Application no: **3/2023/0960**

Address: **Hough Clough Barn Houghclough Lane Chipping PR3 2NT**

Proposal: **Regularisation of change of use of converted workshop to office, annex and holiday let.**

AMENDED SITE PLAN

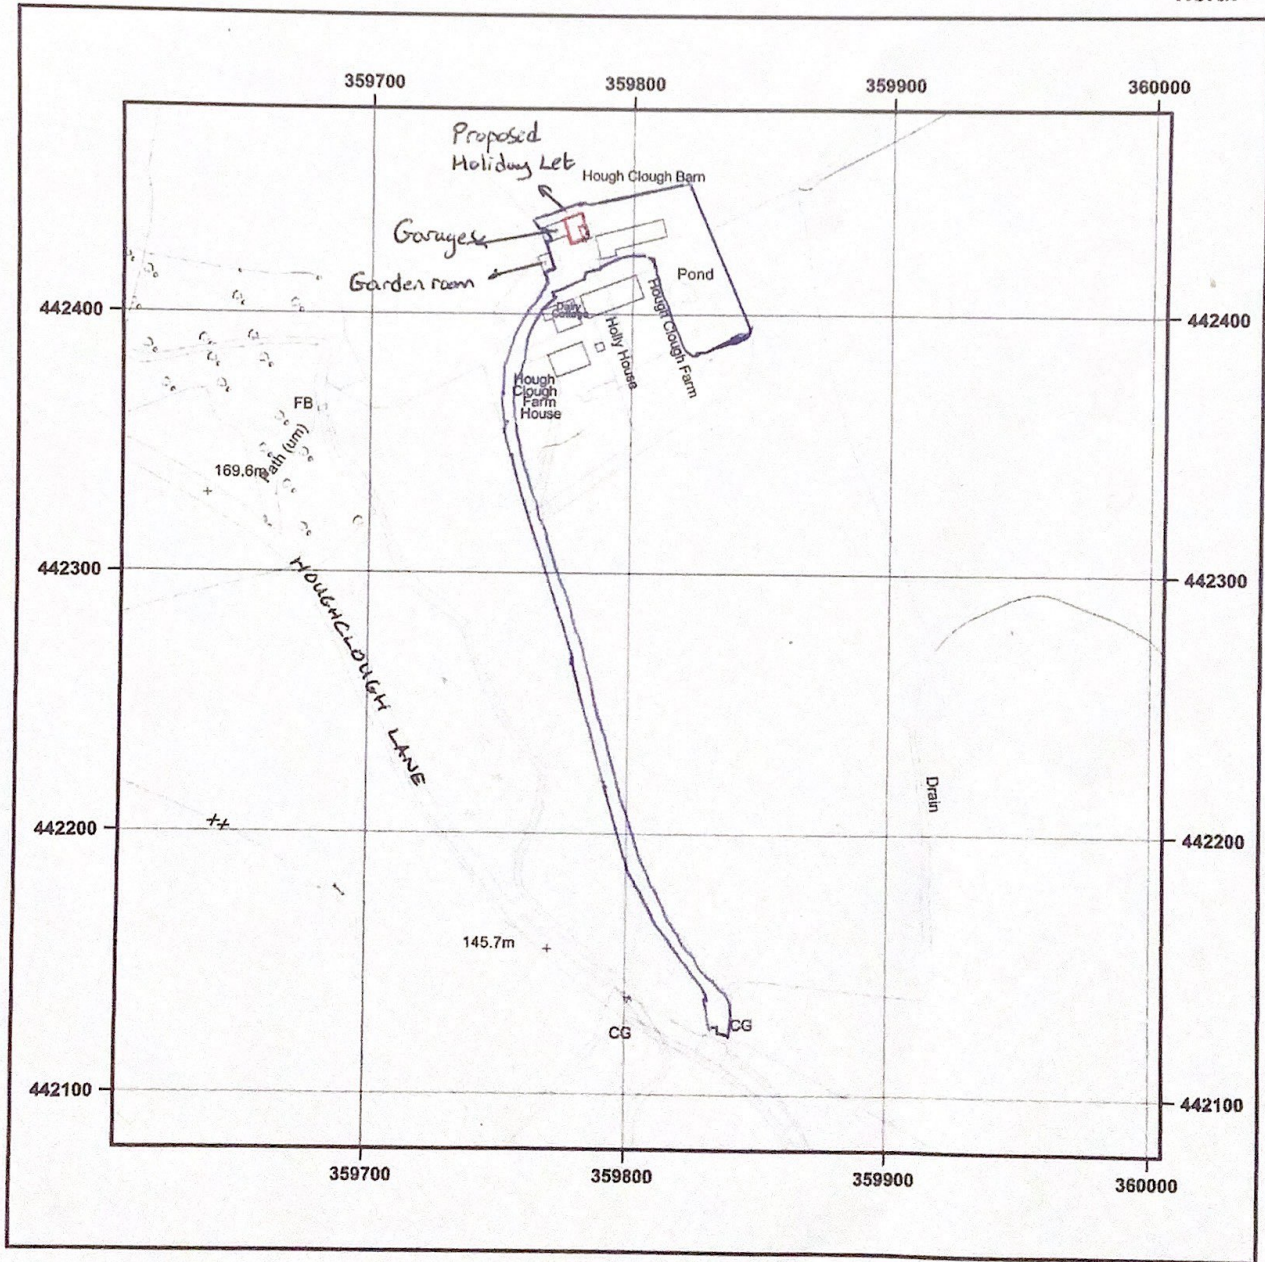
The LHA require the proposal to provide a designated parking space for the one bed holiday let. This to ensure that the parking space does not conflict with the existing dwellings parking arrangements. The parking space should be shown on a parking plan.

PLAN NO 2

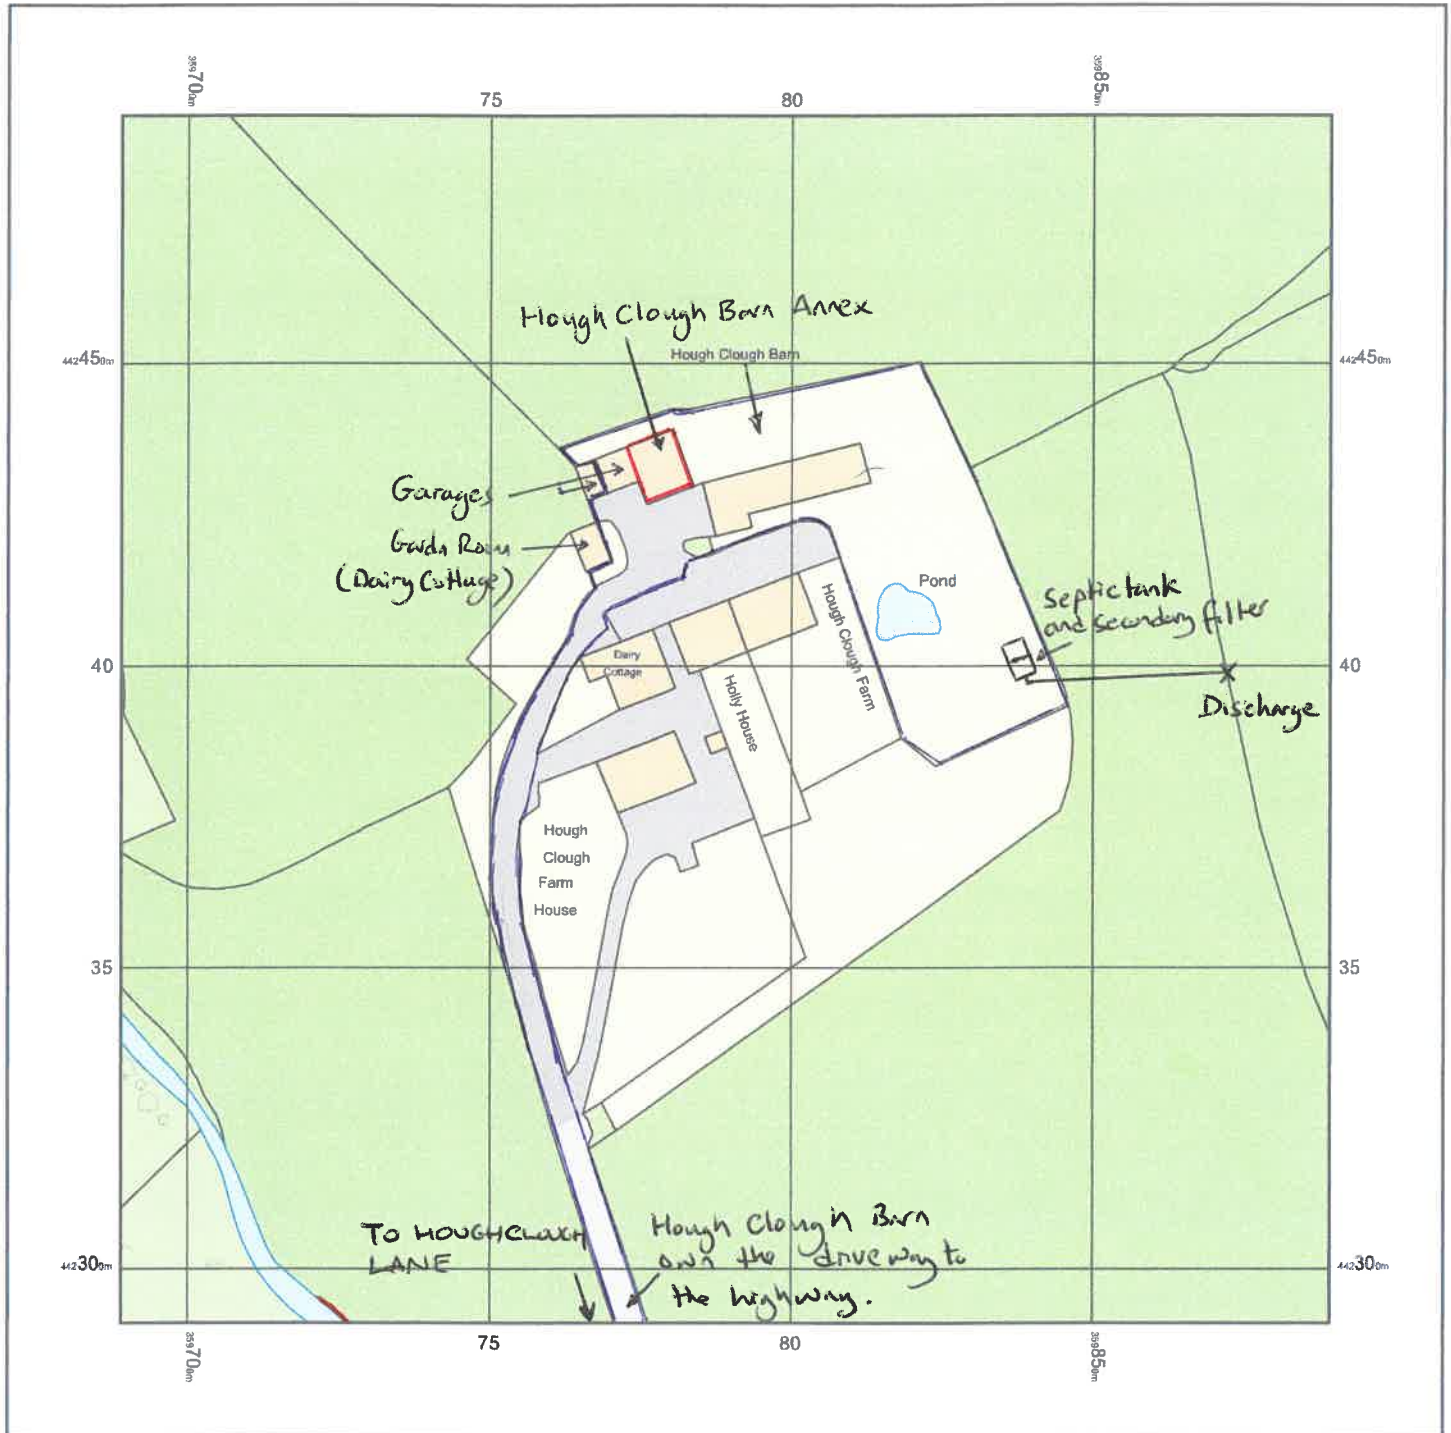
The LHA have reviewed the supporting documents and require a visibility splay drawing to be submitted showing that the access can provide visibility splays of 2.4m x 214m in both directions following the likely intensification of use.

Should the access not be able to achieve these visibility splays, the LHA require a traffic survey to be conducted within the vicinity of the site to demonstrate the 85<sup>th</sup> percentile speeds. These speeds should then be used when providing the required visibility splays.
